FINAL PLAT

COTTAGES AT MESA RIDGE

DATE: 02/28/2022				REVISIONS			
No.	Remarks	Date	By				
1	ADDRESS COMMENTS	7/29/22	KPB				
2	ADDRESS COMMENTS	8/05/22	KPB				
				PCD File No. SF2214			
				BARRON LAND			
				BOUNDARY & MAPPING & SURVEYING & CONSTRUCTION 2790 N. Academy Blvd., Suite 311 P: 719.360.6827 Colorado Springs, CO 80917 F: 719.466.6527 www.BARRONLAND.com			
				PROJECT No.: 20-035 SHEET 1 OF 3

PROJECT No.: 20-035	SHEET 2 OF 3
---------------------	--------------

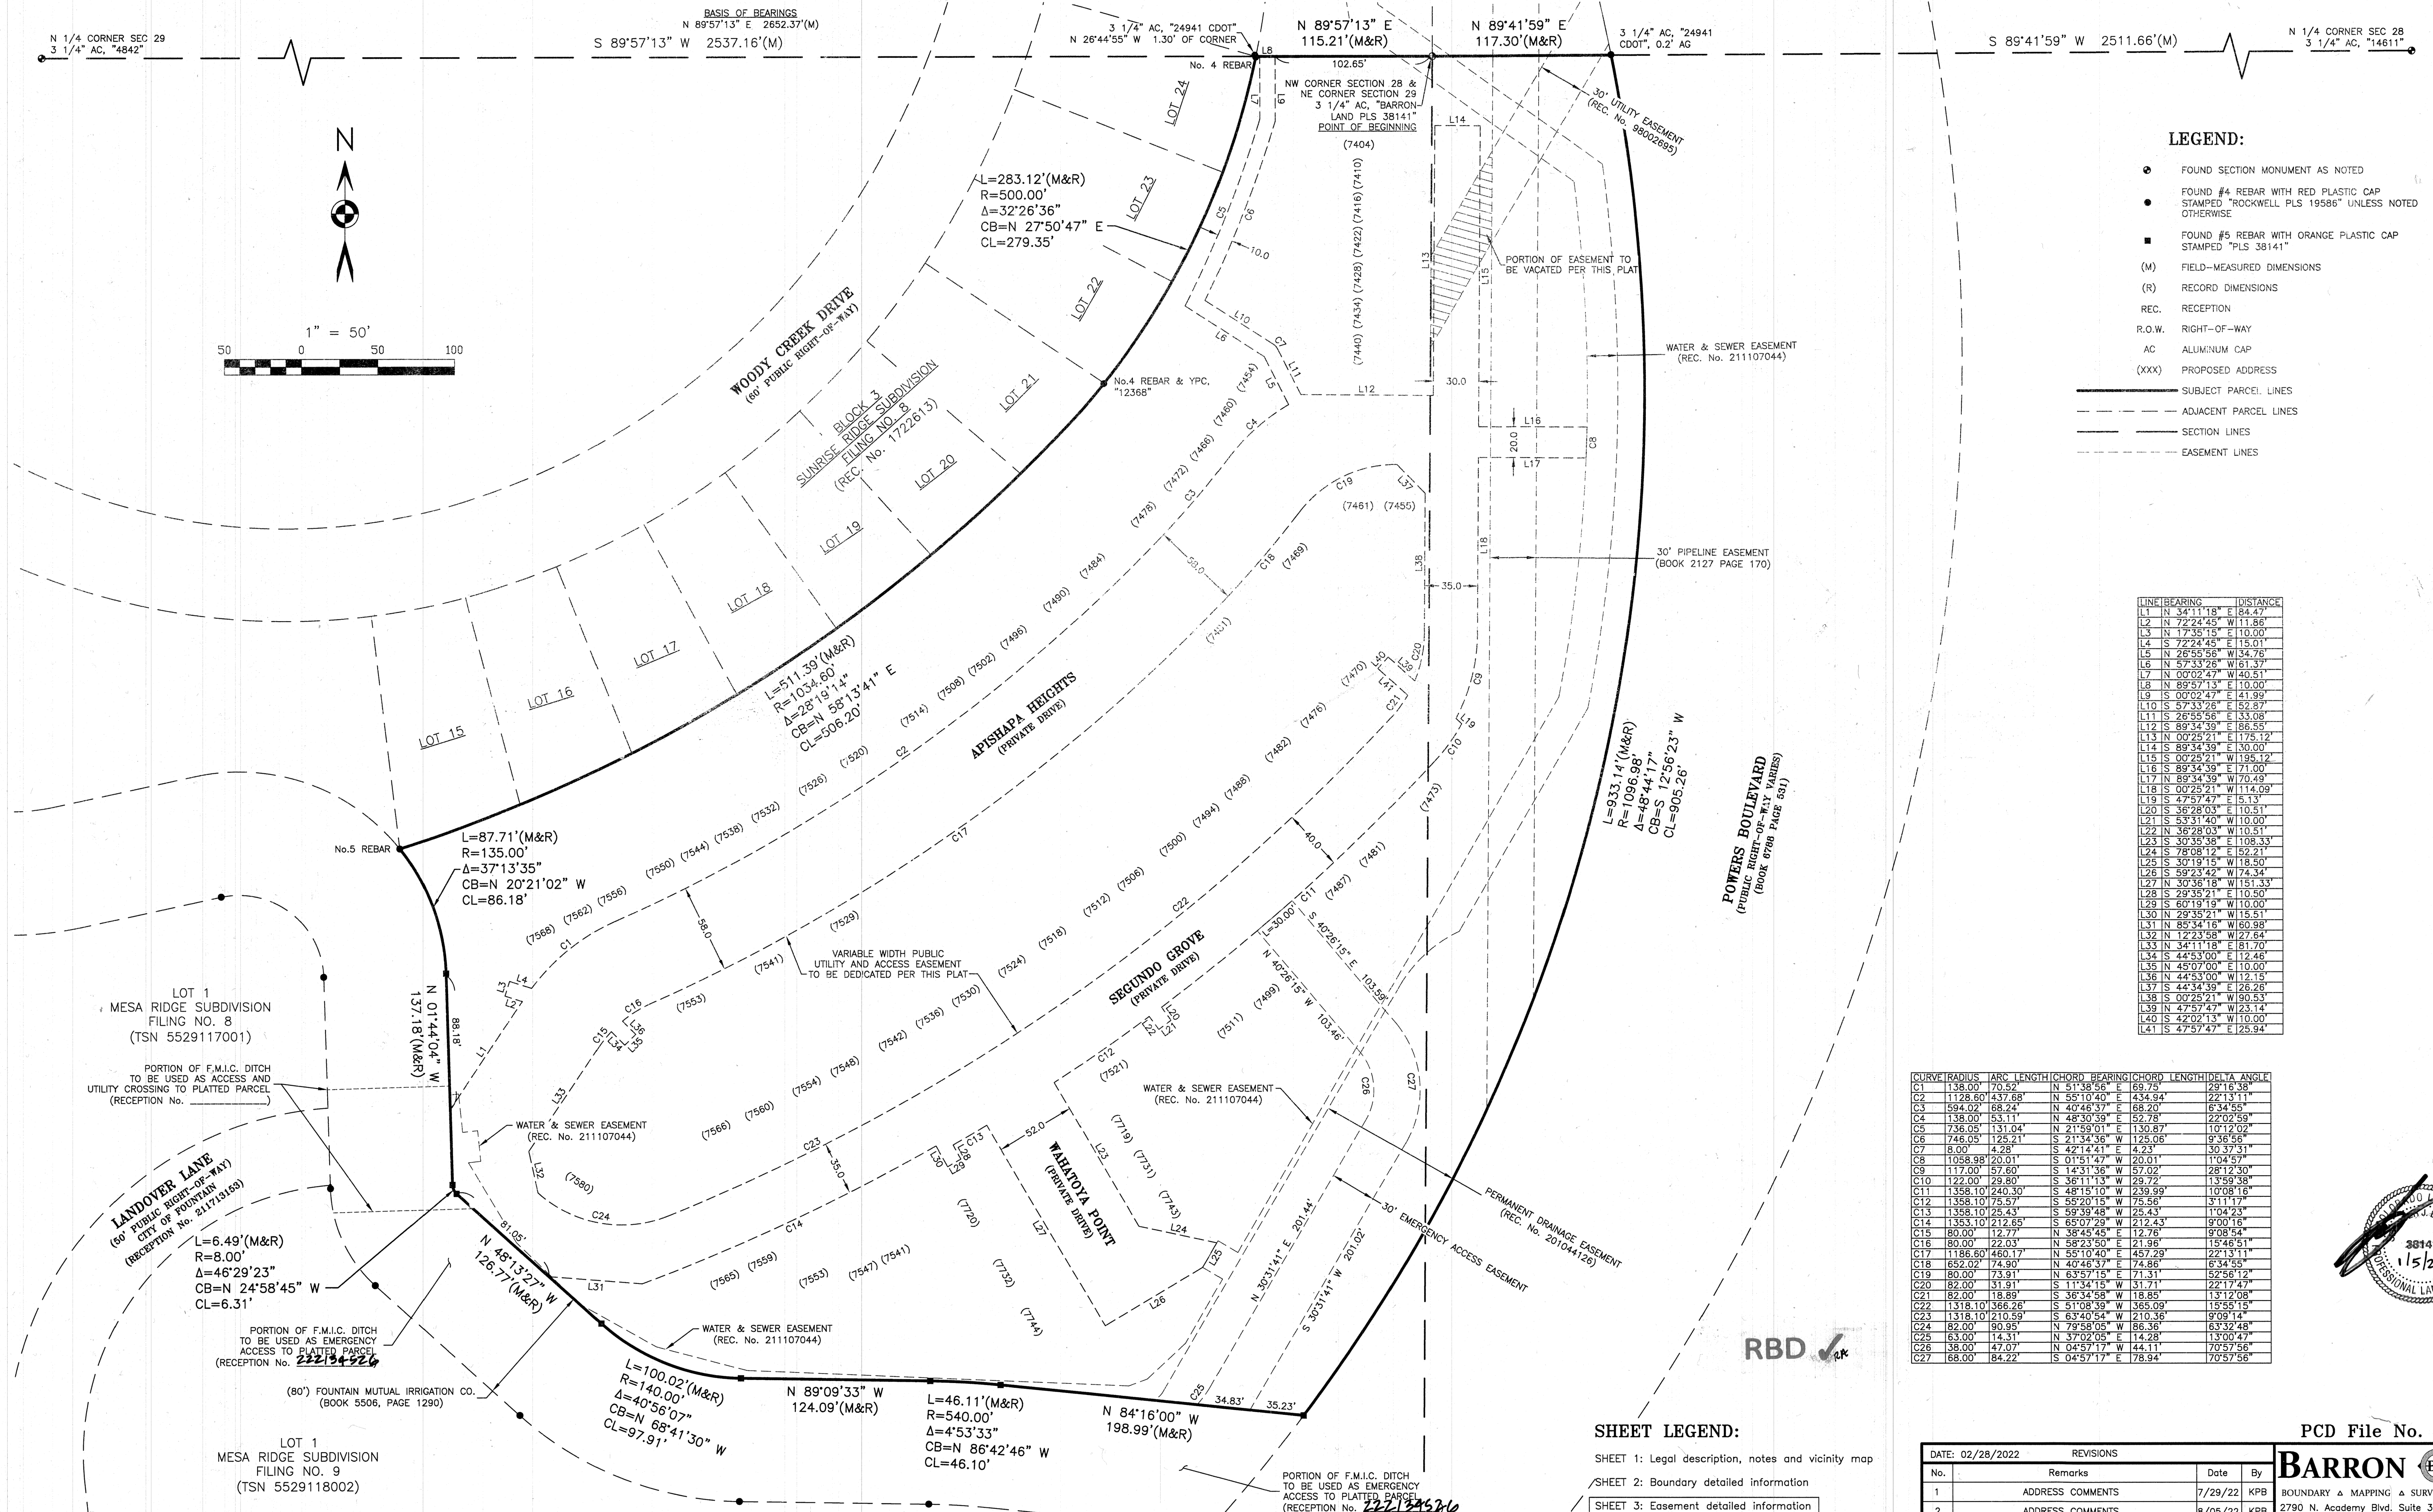
Please label Basis of Bearings.
Rafael Bombacini
